Application No: AW/353/20/OUT
Site Address: Land adjacent to 1 Cambridge Walk Aldwick PO21 5RL
Description of works: Outline application with some matters reserved for 1 No. new dwelling.

Thank you for your internet representation made on 25th February 2021 which has been recorded as an objection with the comments as follows:

1, Cambridge Walk, Aldwick, West Sussex, PO21 5RL

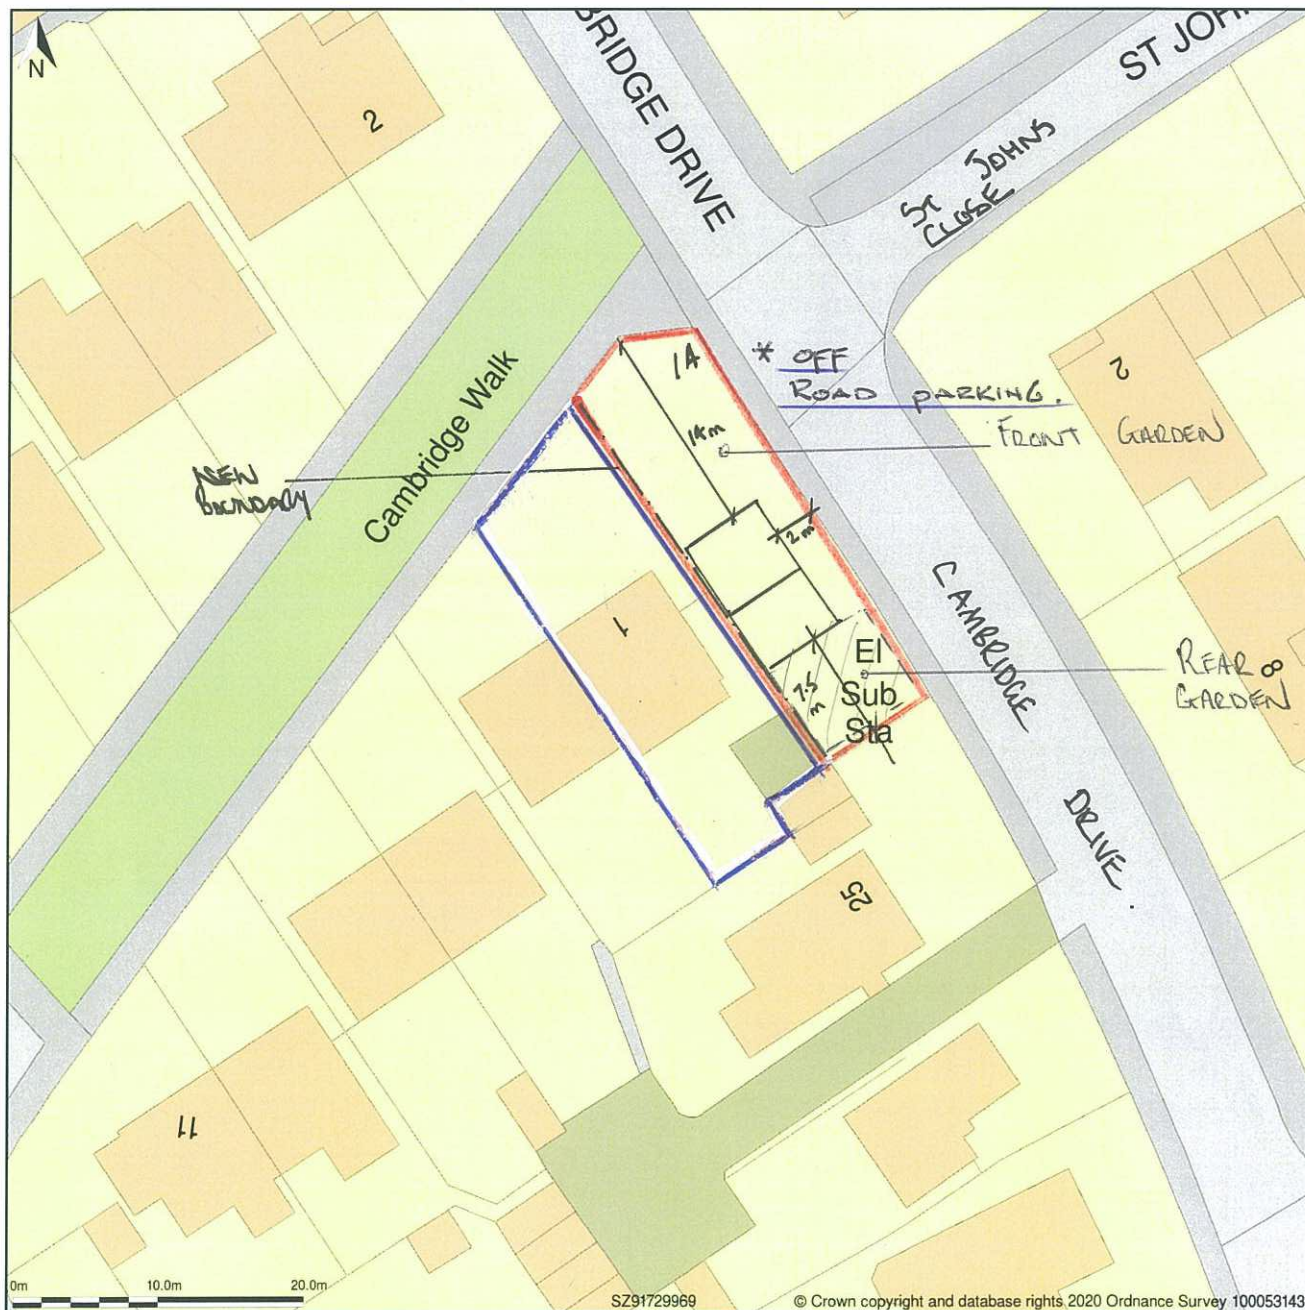
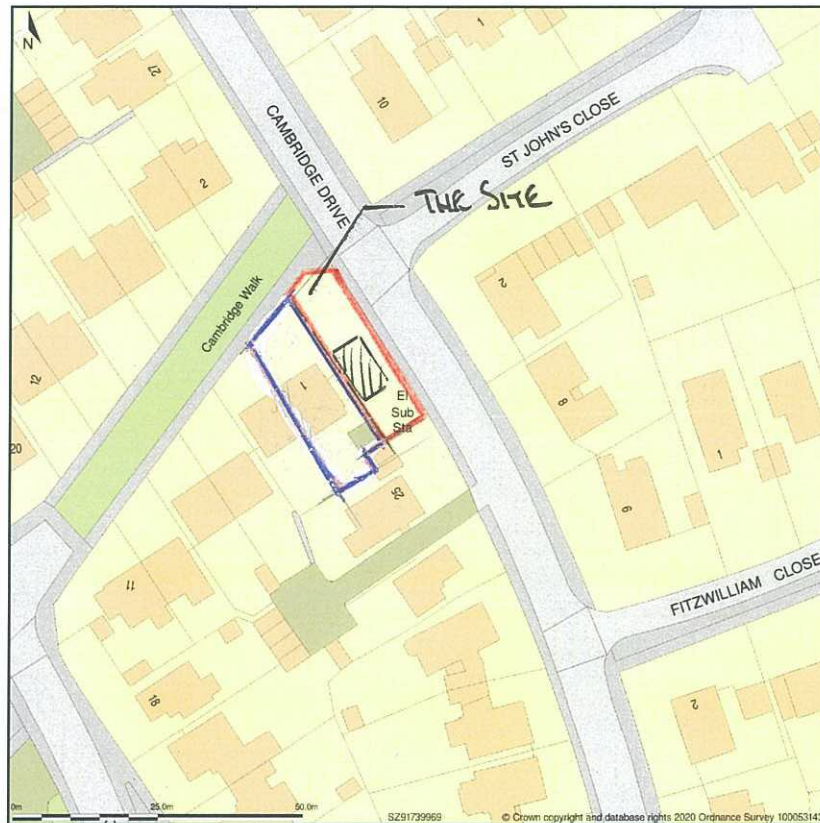
Having looked at plans we feel that the footprint of a two bedroom bungalow would not be viable. If it were to be of a two floor build, we would strongly object, as this will overlook surrounding properties. A large silver birch tree will have to be removed. In the past, some problems have occurred with the drainage systems. If the land leading to the substation is to be incorporated with the property, how will this be accessed? Looking out on a six foot wooden fence around the boundary of the property is not in keeping with the estate. I trust these comments will be given some consideration. Thankyou. W.Page
